Traffic & Safety - Access Permits

SH-024G / 6365 E Platte Ave
El Paso County

October 12, 2026

RE: 6365 E Platte Ave Conversion to Fire District Bldg.

① SITE PLAN

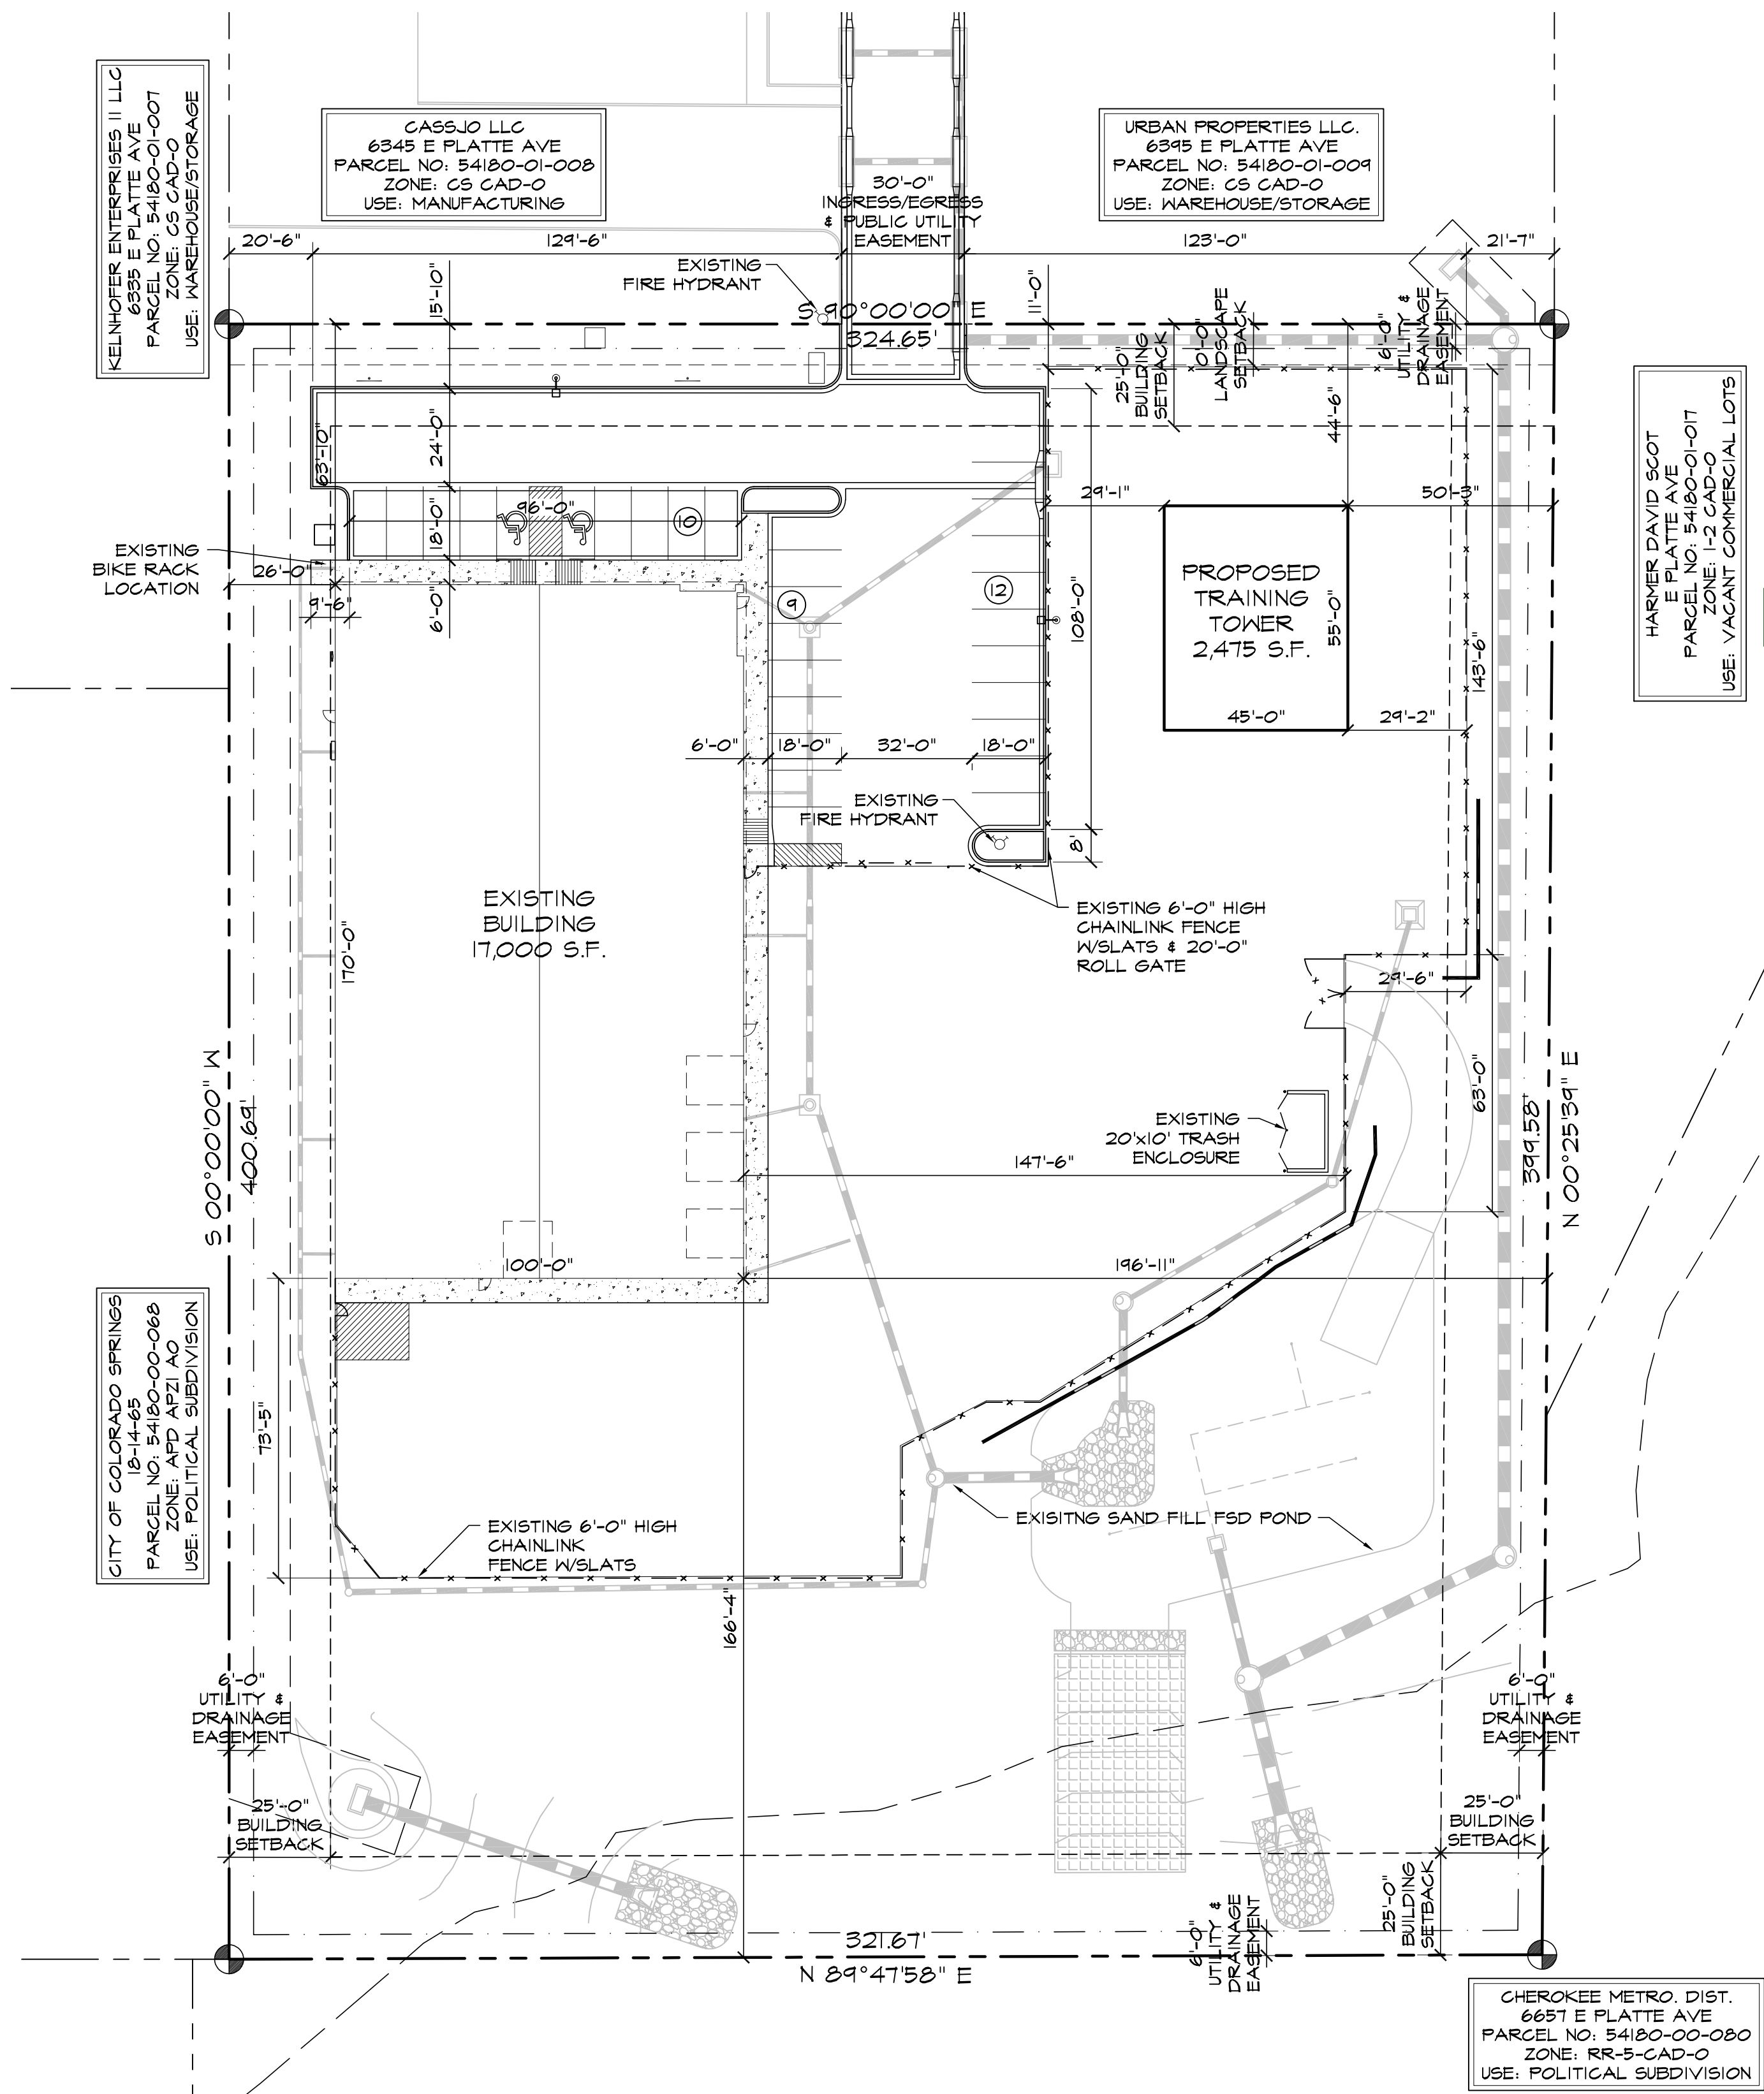
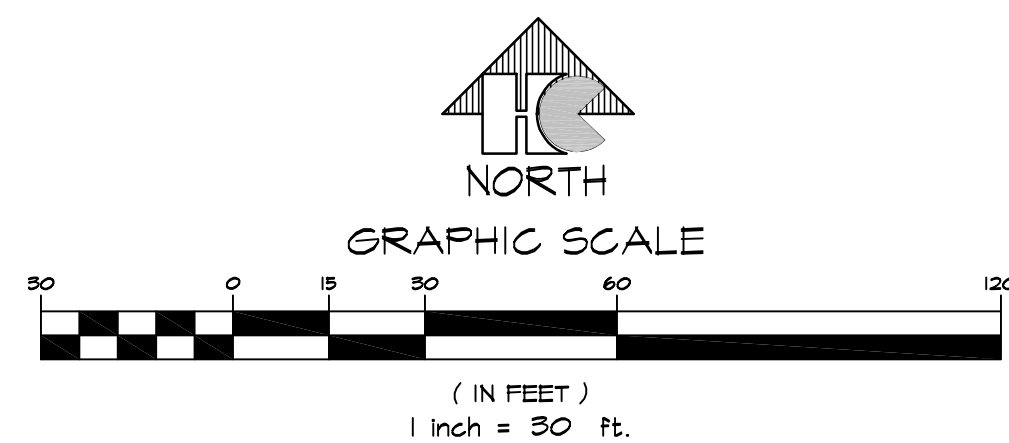
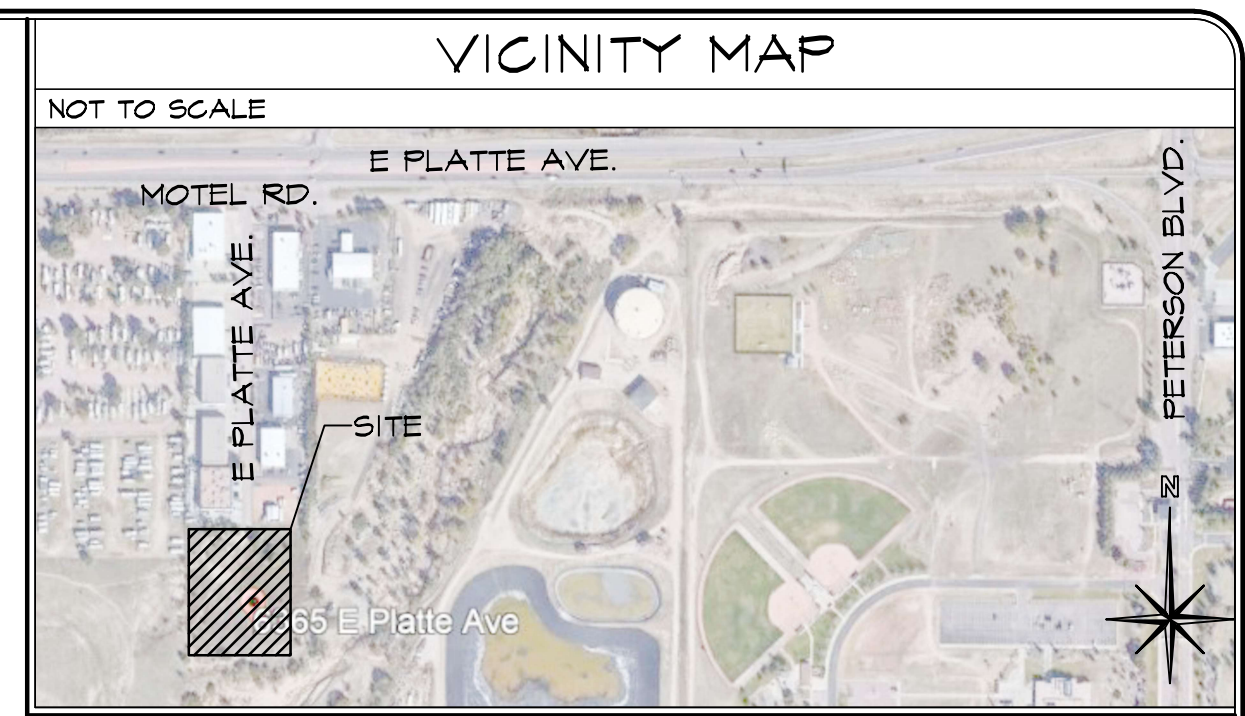
- This location is currently permitted through Access Permit #226014.
- CDOT requires installation of right-of-way fencing to be installed for the length of the auxiliary lane (MP311.16 to MP311.39, approximately 1200 lf), between the auxiliary lane along US 24 and the entrance to Motel Road serving 6365 E Platte Avenue.
- The State Highway Access Code requires an access permit if the proposed vehicle volumes increase by 20 percent or more, the development is adjacent to the state highway, and/or significant changes in the use of the property are made which will affect access operation, traffic volume and/or vehicle type
- State Highway improvements are required at this location.
